**Final Report on the joint World Heritage Centre / ICOMOS / ICCROM
Advisory Mission to Stonehenge, Avebury and Associated Sites (c.373bis)**

19-21 April 2022

The A303 Amesbury to Berwick Down Road project (the Scheme), which proposes to upgrade the existing A303 road that transects the Stonehenge component of the WHS, is part of a wider scheme for the A303/A358/A30 route to turn it into a continuous dual carriageway between the south-east and the south-west of England. In March 2020 £1.7 billion was allocated by the UK Government towards implementing the A303 road improvement.

PROPOSED BORED TUNNEL - (WORK No. 1F)

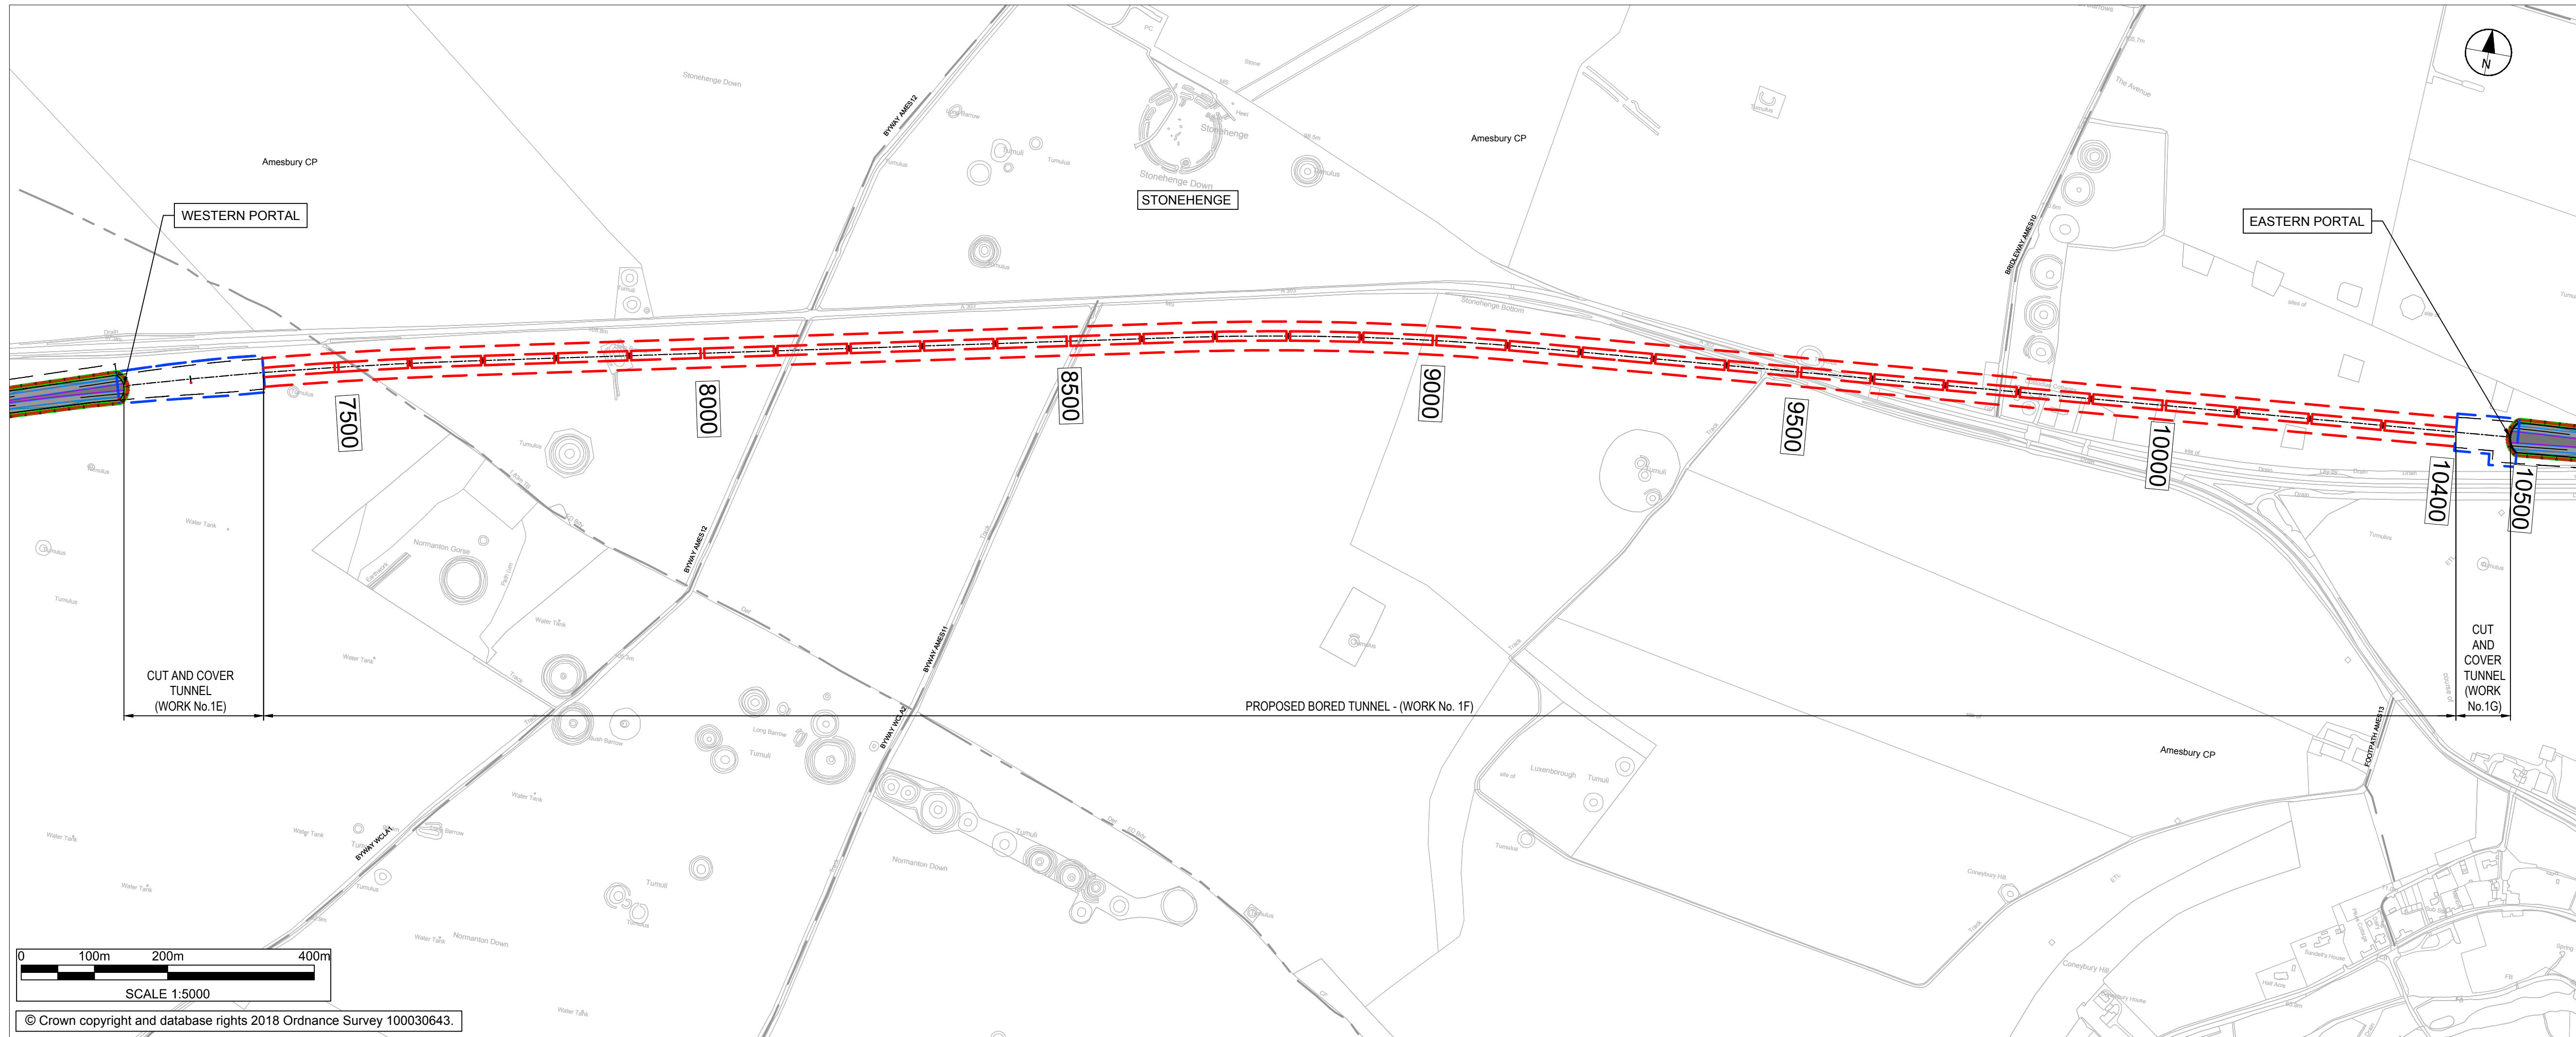
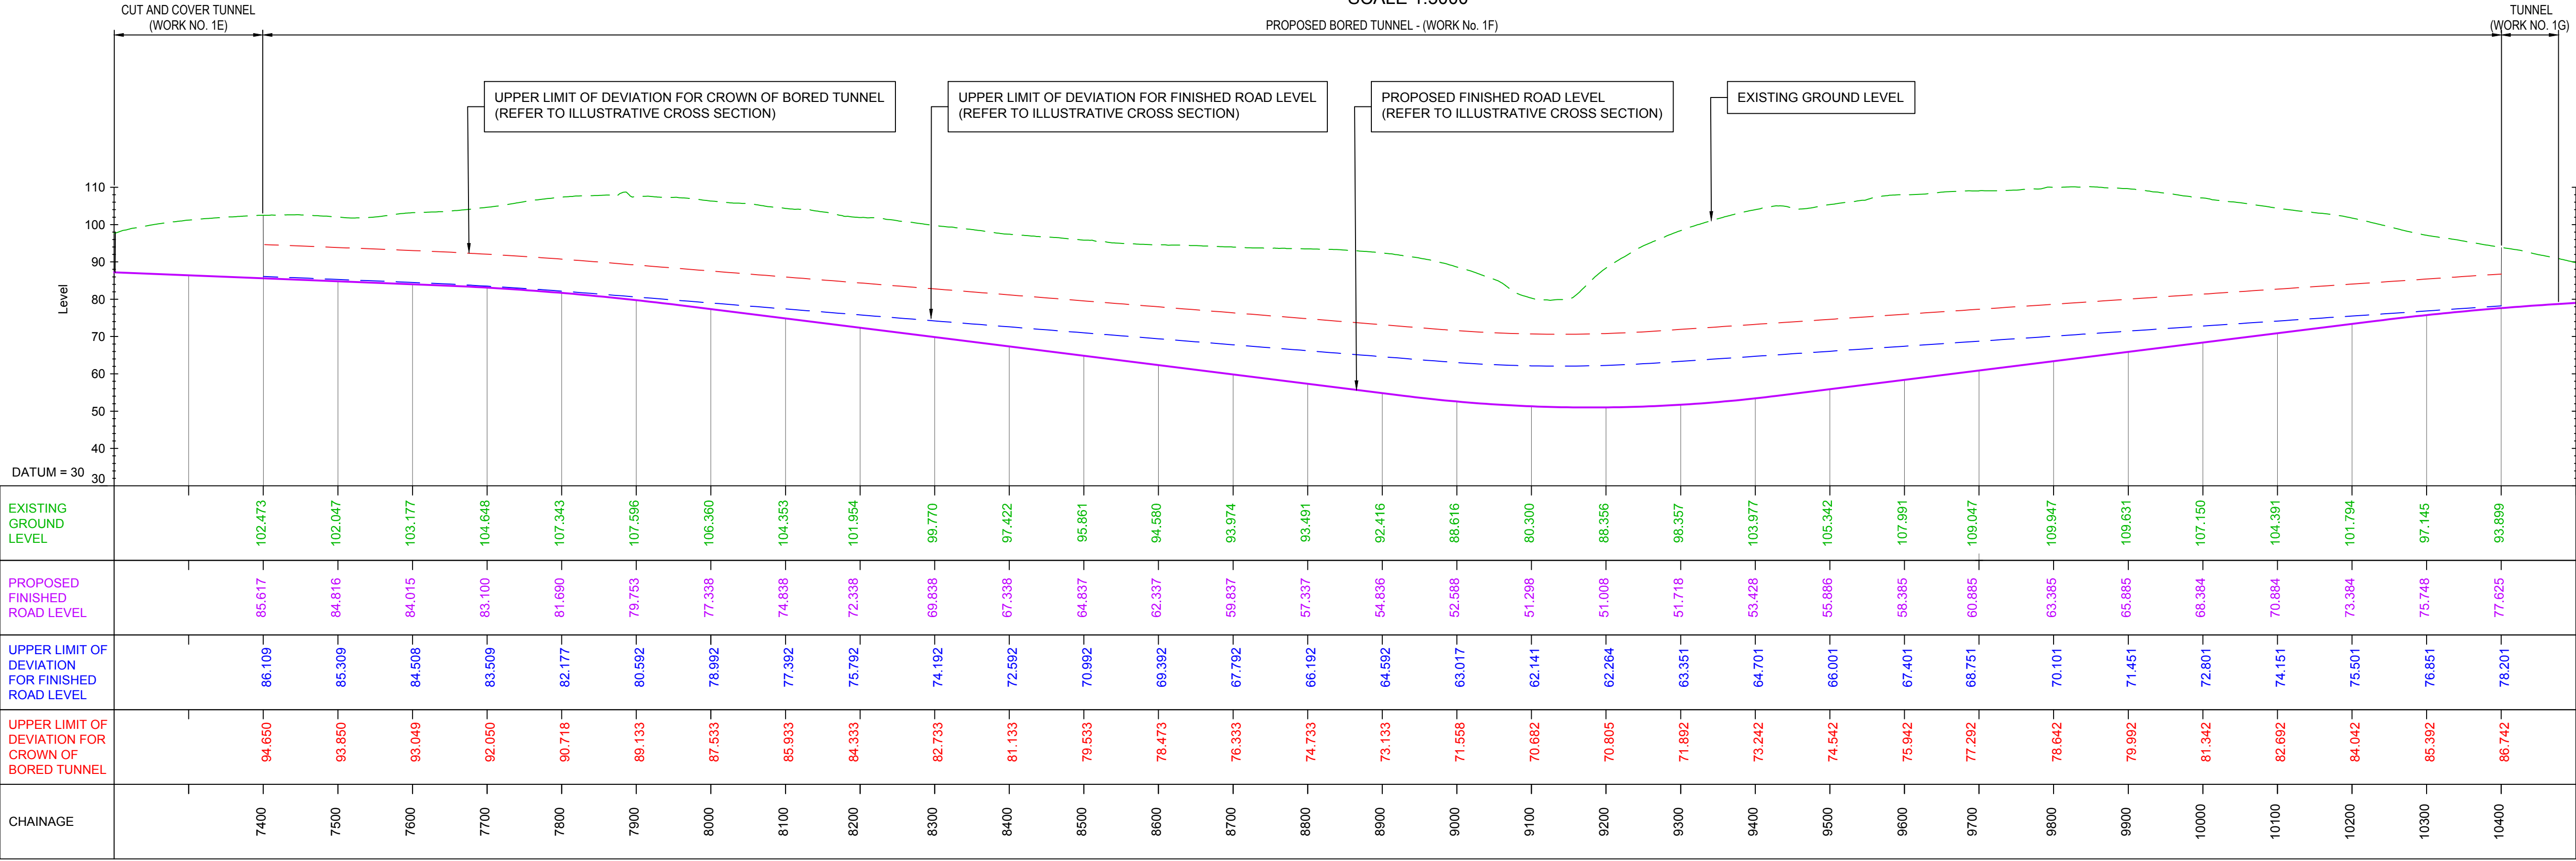
The Scheme currently includes a 3.3km twin tunnel, two short, covered sections, plus approximately 2km of dual carriageway in cuttings and a land bridge. The tunnel would remove the road from the central part of the WHS, but the construction of dual carriageways in cuttings at either end of the tunnel would adversely and irreversibly impact on the integrity of the WHS and the OUV of the property, through removal of archaeological features and deposits, through disrupting the spatial and visual links between monuments, and as a result of its overall visual and functional impact, as well as affecting the overall conceptual understanding of the property as being whole and intact.

The proposed western portal and associated dual carriageway, within a cutting, would have an unacceptable and inappropriate adverse impact on the setting of the Winterbourne Stoke Barrow Group and the physical and visual integrity of the WHS and the Scheme should not proceed without substantial amendment to avoid this impact.

The proposed western portal and associated dual carriageway, within a cutting, would also have an adverse impact on the archaeological resources which would be excavated, and this impact should be minimised.

Extending the proposed tunnel to the west, beyond the boundary of the WHS would enable greater re-connection between the southern and northern sections, an improved setting for the Winterbourne Stoke Group and reduce impacts on archaeological resources within the WHS and on its integrity. However, it is recognised that a longer tunnel would be challenging in view of topographic considerations and design options, and may involve moving the Longbarrow junction back towards the western edge of the WHS.

It is understood that land bridge 4 cannot be made wider than 150m, without becoming a ‘tunnel’, which would require considerable additional infrastructure; therefore, if a wider land bridge or even multiple land bridges were to be considered, it would be preferable to extend the proposed underground section of the A303 further to the west.

If the Scheme proceeds, the minimum change required, in light of the above considerations, would be an extension of the underground section of the western approach (in tunnel and/or cut-and-cover) at least to the western boundary of the WHS. The western portal should be re-located as far to the west as reasonably practical, thereby reducing the length of the cut-and-cover section and minimising the extent of archaeological resources which must be removed.

Before considering the proposed Development Consent Order, the State Party should modify the design of the Scheme to include an extension of the underground section of the western approach (in tunnel or cut-and-cover) at least to the western boundary of the WHS. Ensuring continued stakeholder engagement in these modifications may demand some additional steps such as notifying all parties who participated in the original examination and give them the opportunity of submitting representations on the proposed change. It is recognised that under UK law the steps to approve and implement the modified Scheme may require a series of approvals, but it is strongly advised that the Scheme does not proceed until and unless modified as recommended in this report.
